Recommendation Report for Planning Permission for Works or Extension to a Dwelling

REF NO: R/50/20/HH

LOCATION: 47 Priory Road
Rustington
BN16 3PZ

PROPOSAL: Side extension over garage, single storey rear extension and front porch.

DRWG TITLE: **Proposed plans**

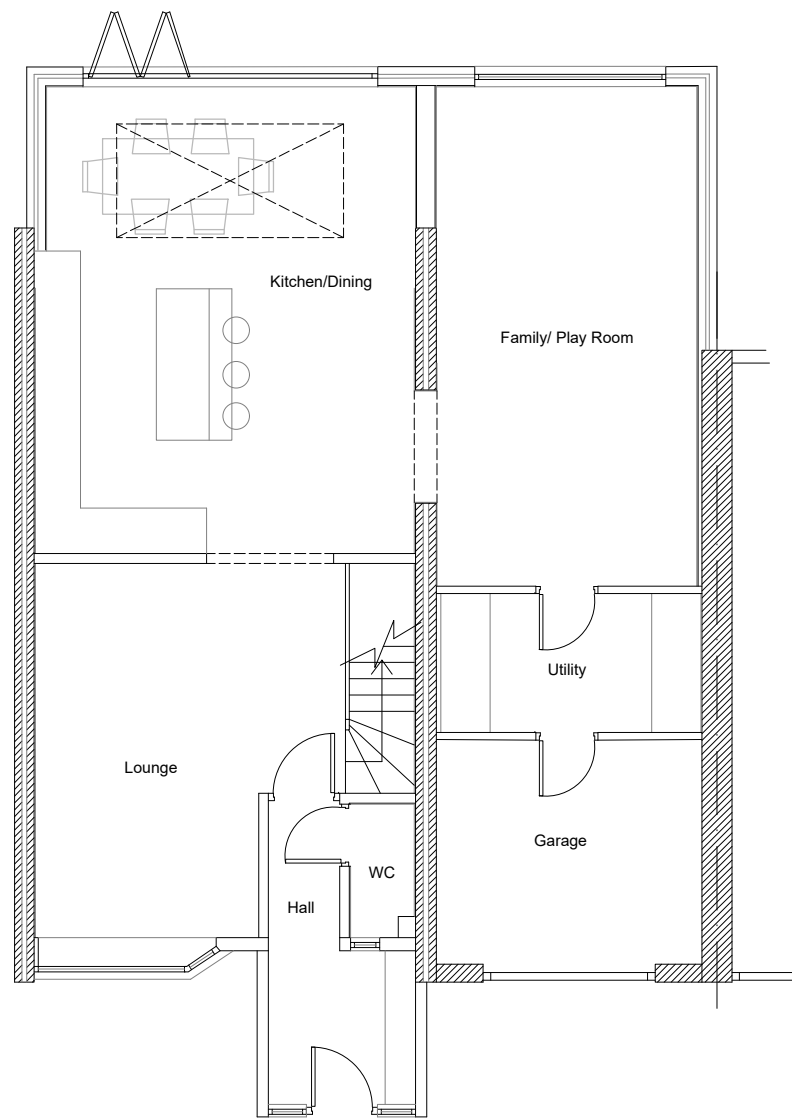
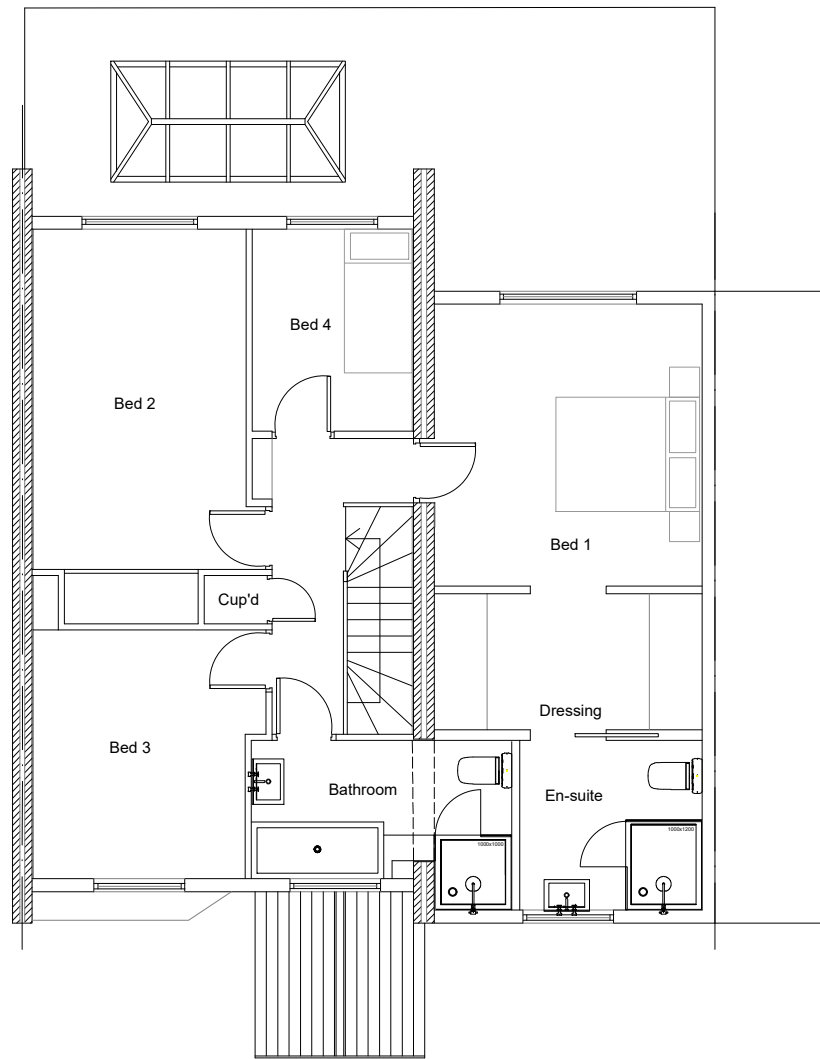
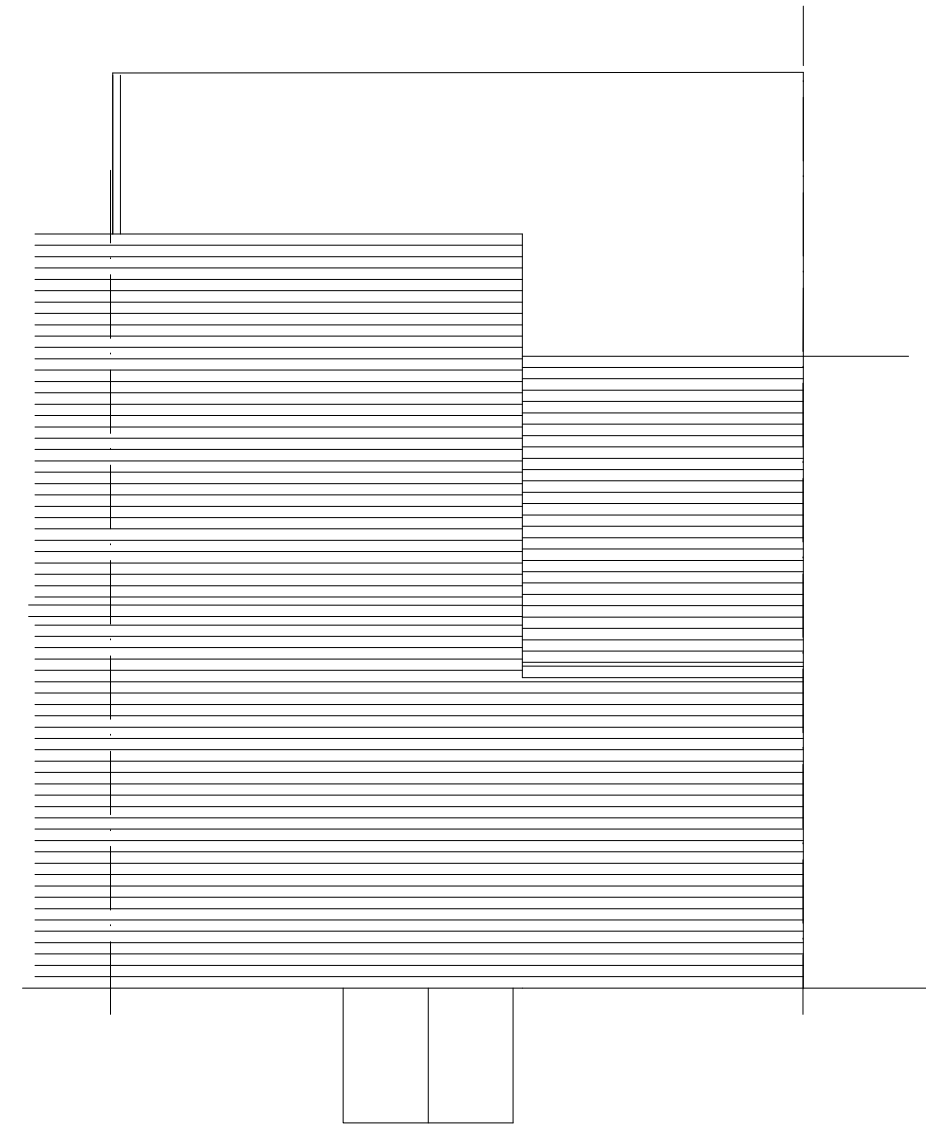
- Are windows situated at each end? If there were to be future development, views would be blocked.
- How far back does the side extension extend to the rear?

Windows are situated to front/rear elevations. The side extension meets the rear elevation of the existing ground floor side projection.

DRWG TITLE: **Proposed Elevations**

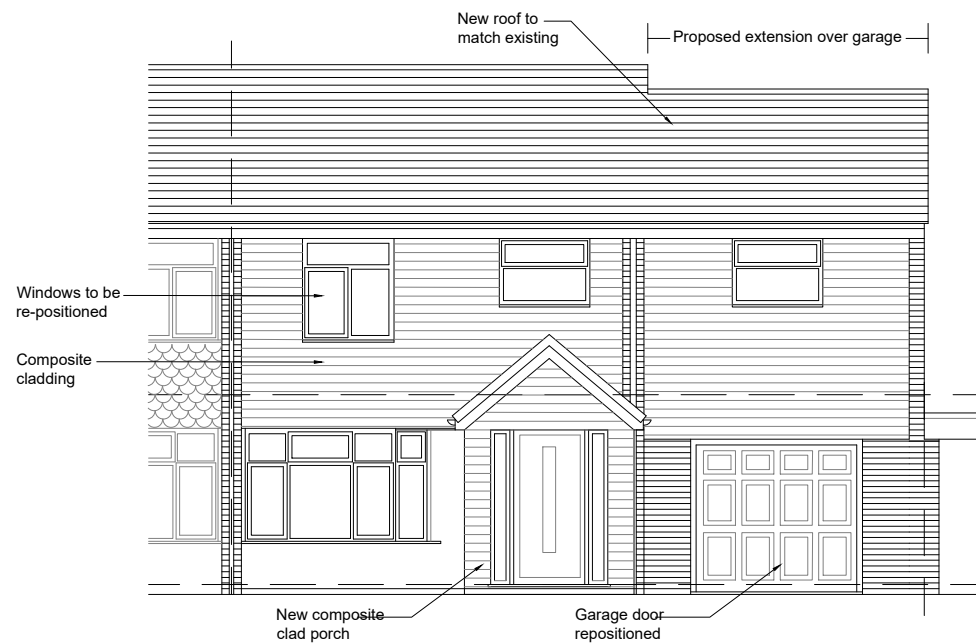
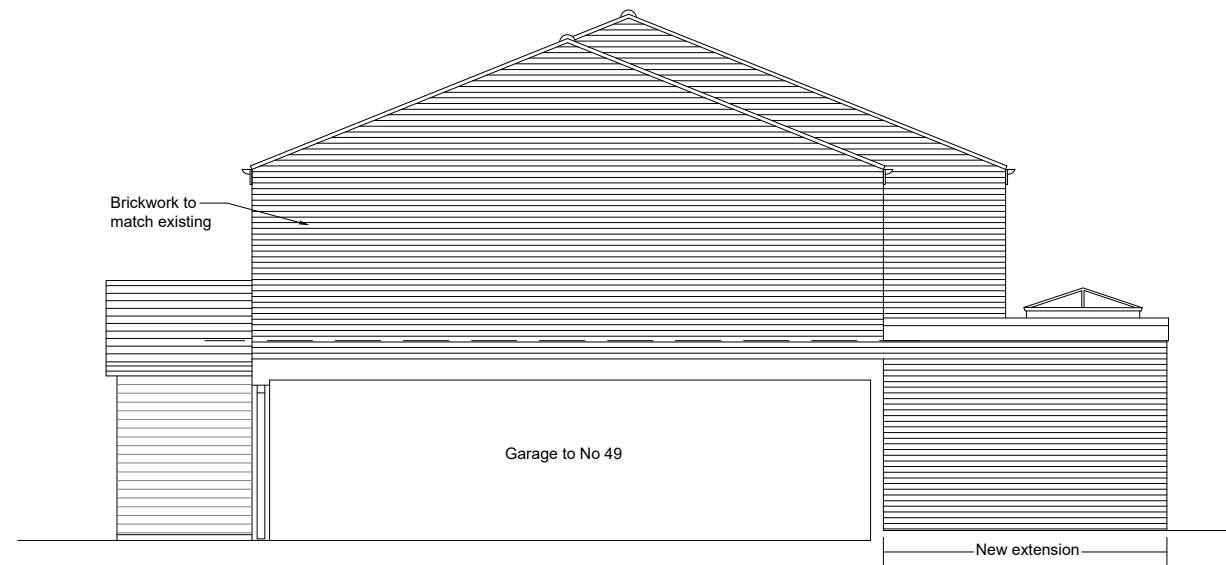
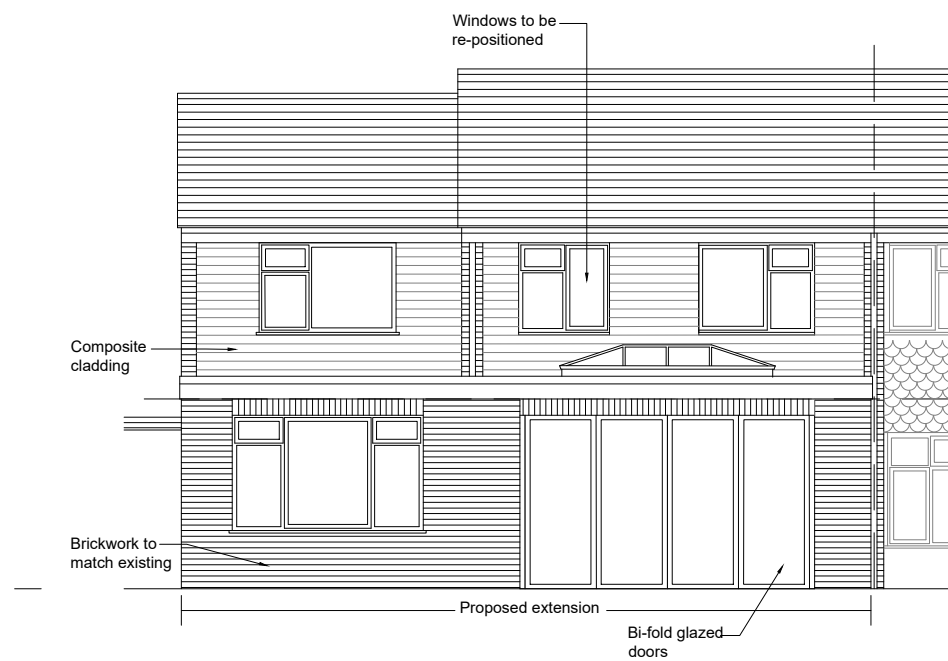
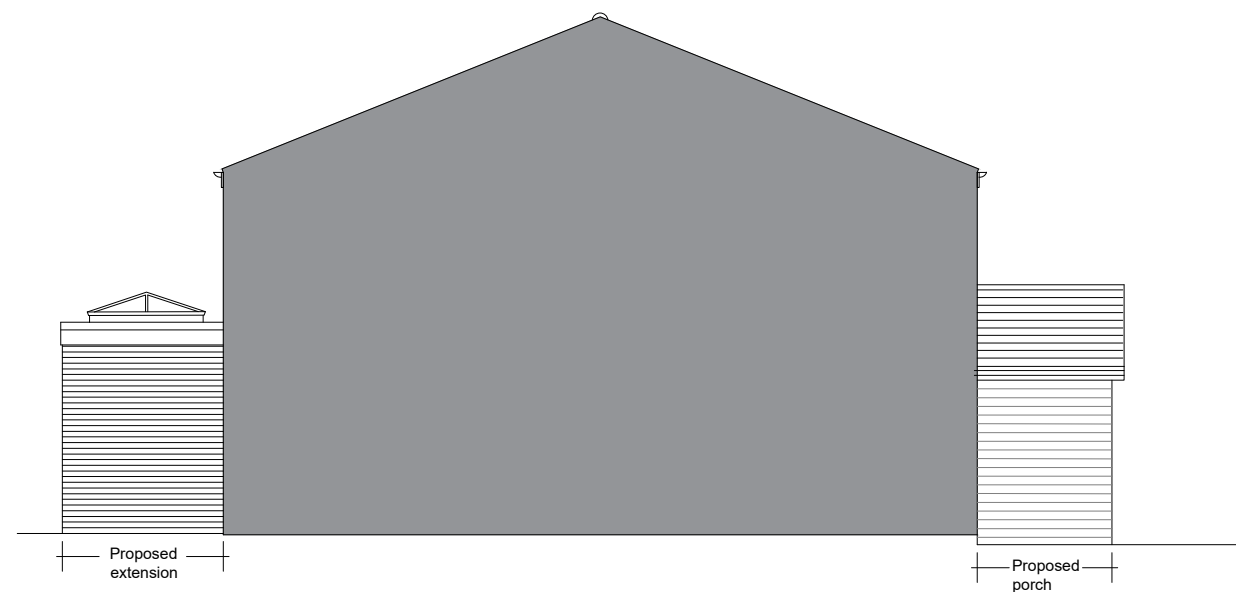
The porch will be visible from the street scene, and would be the first of its kind along the four dwellings that the dwelling is sited within. Whilst the porch in principle is out of character with the area, it is considered it is of a good design, and acceptable form. Resultant of these factors, the porch is not considered to result in any significantly harmful impact upon the host dwelling, or the locality.

The side extension projects from the Northern elevation of the dwelling, which will be visible from the street scene. Whilst it is noted the extension would have an impact upon the spatial pattern of the locality, there is not considered to be a uniform pattern along the street scene and, there is no harm upon this spatial pattern identified. The extension appears well integrated with the dwelling, and have no significant harm upon the locality.
